**The National Construction Code Volume One
Schematic Design Report for SSDA Submission**

**The Children's Hospital at Westmead
Redevelopment
Multi Storey Car Park**

**Health
Infrastructure**

Date: 22 January 2021

1 PROPOSED ELEVATION - NORTH  
**North**

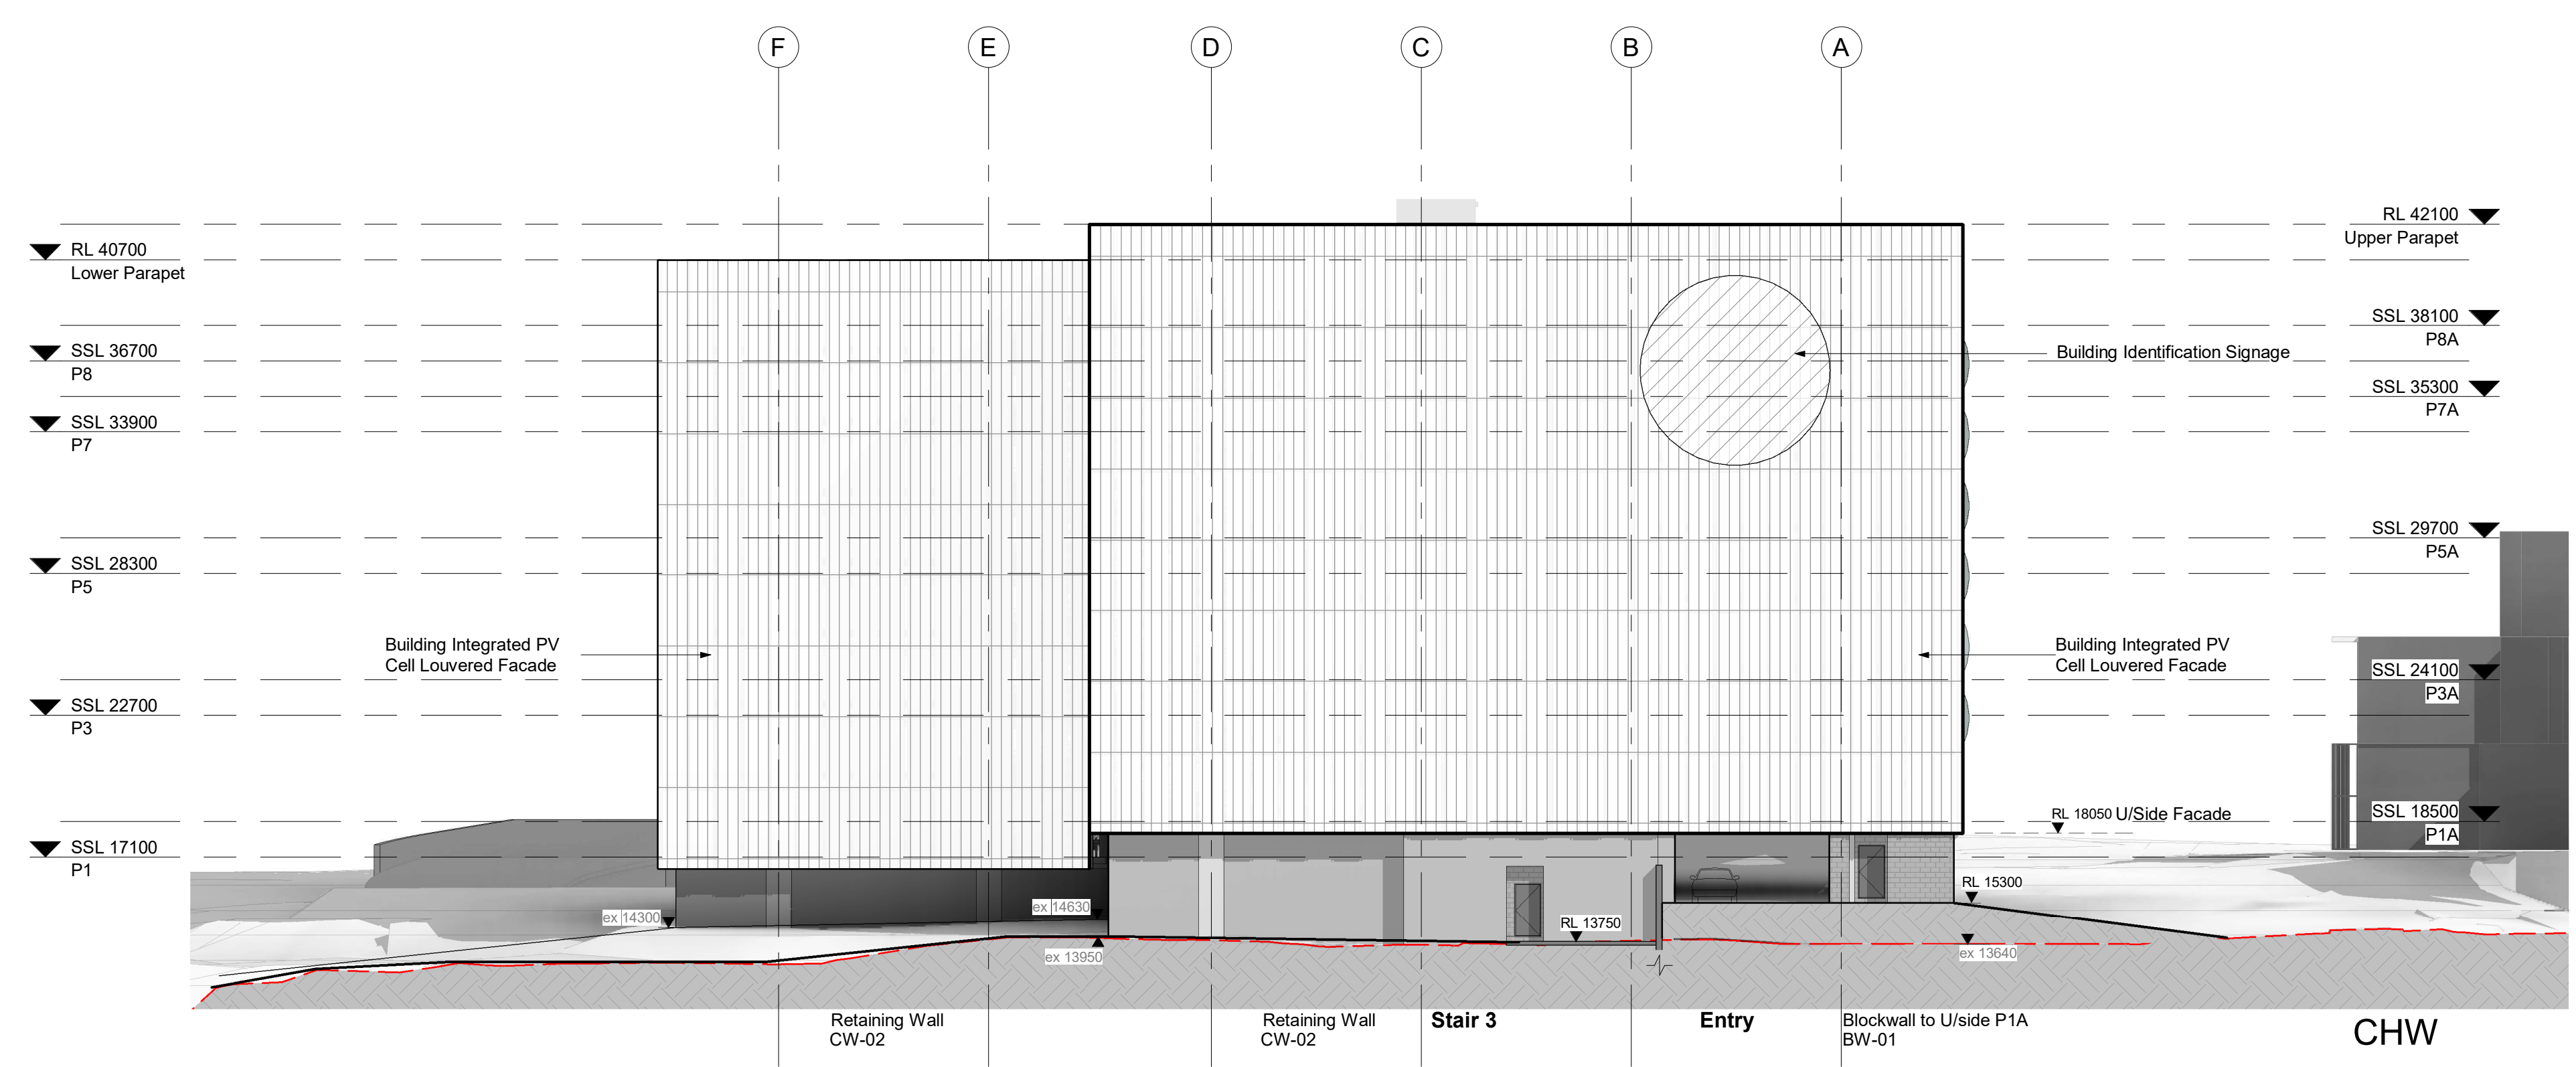
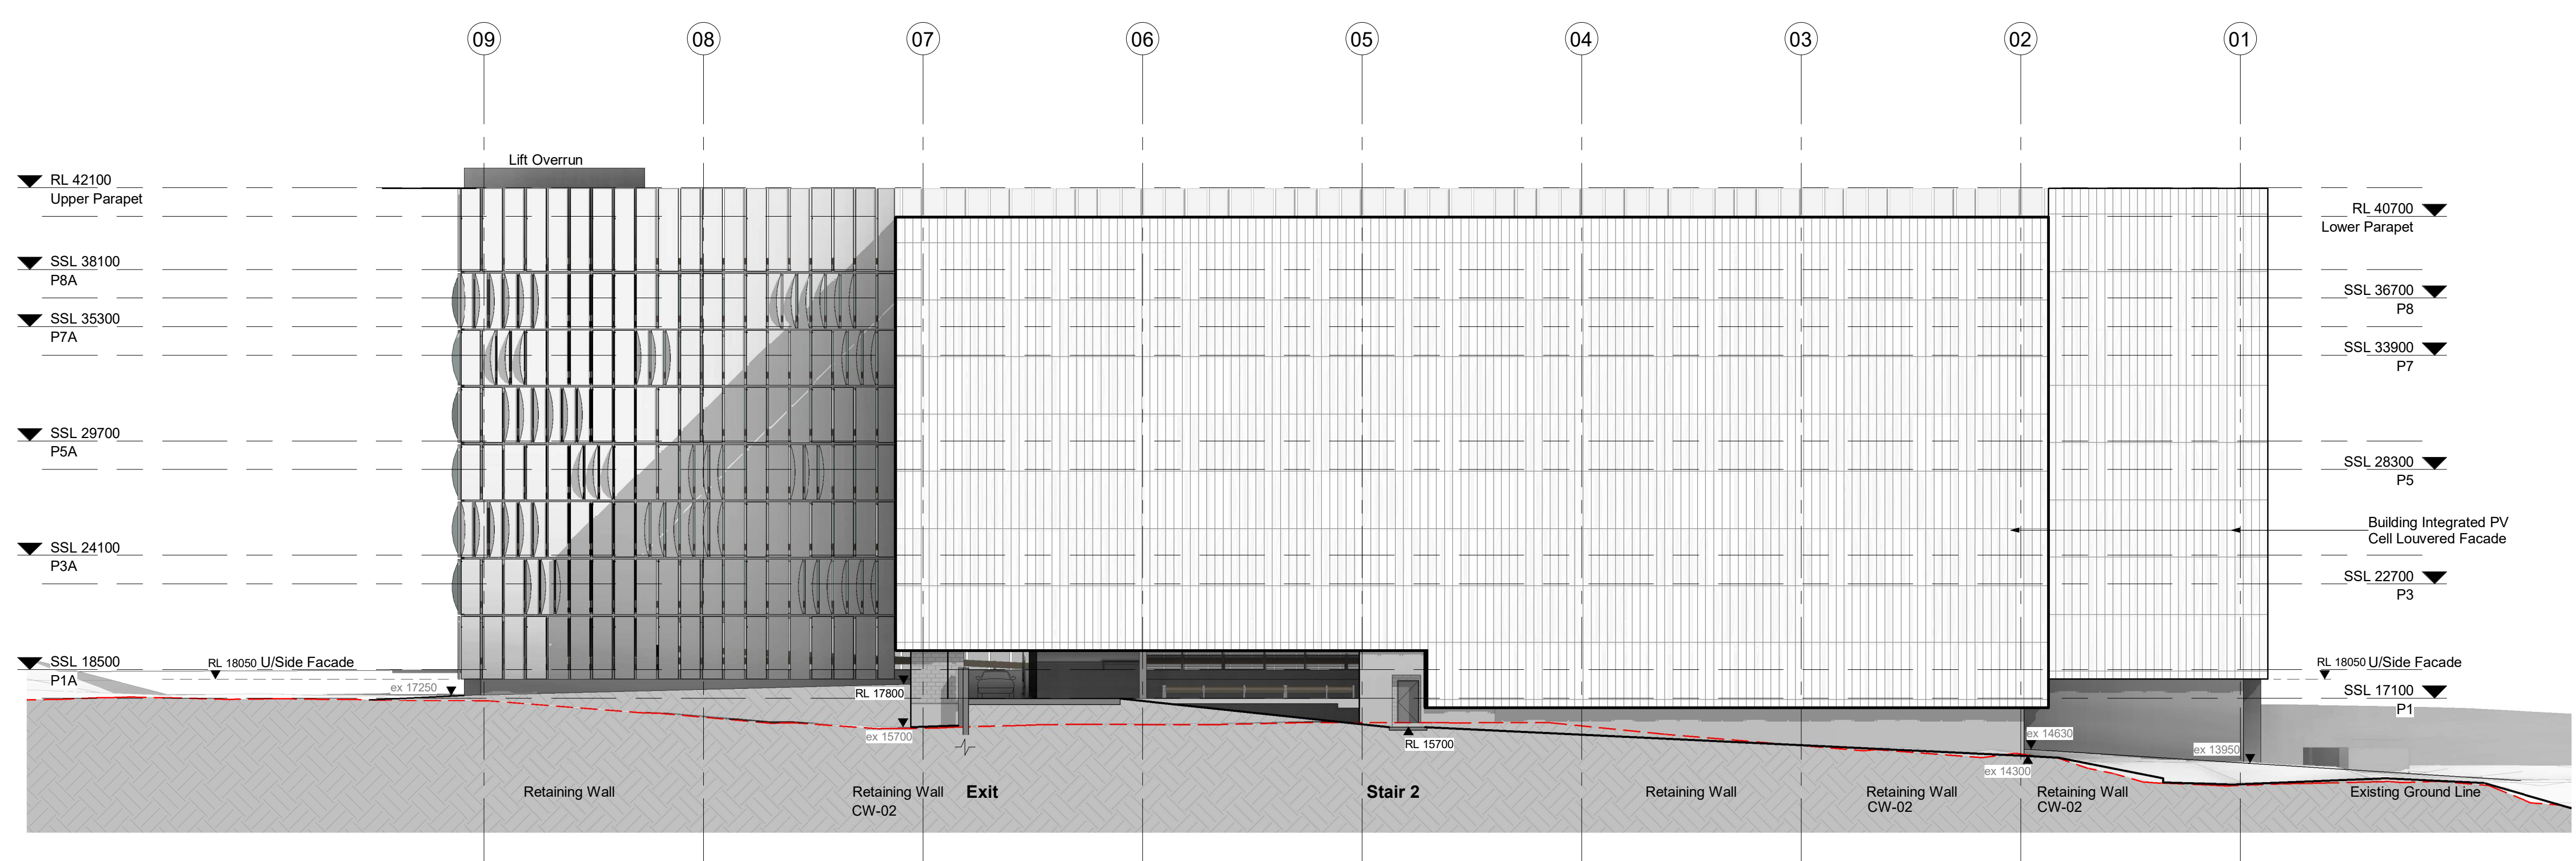
Figure No. 2 – Northern and Eastern façades of the Multi Storey Car Park required to have openings on each storey with a minimum of 50% of the wall area

Based on the Schematic Design Architectural Drawings submitted, the proposed façade is capable of complying with the open deck car park provisions.
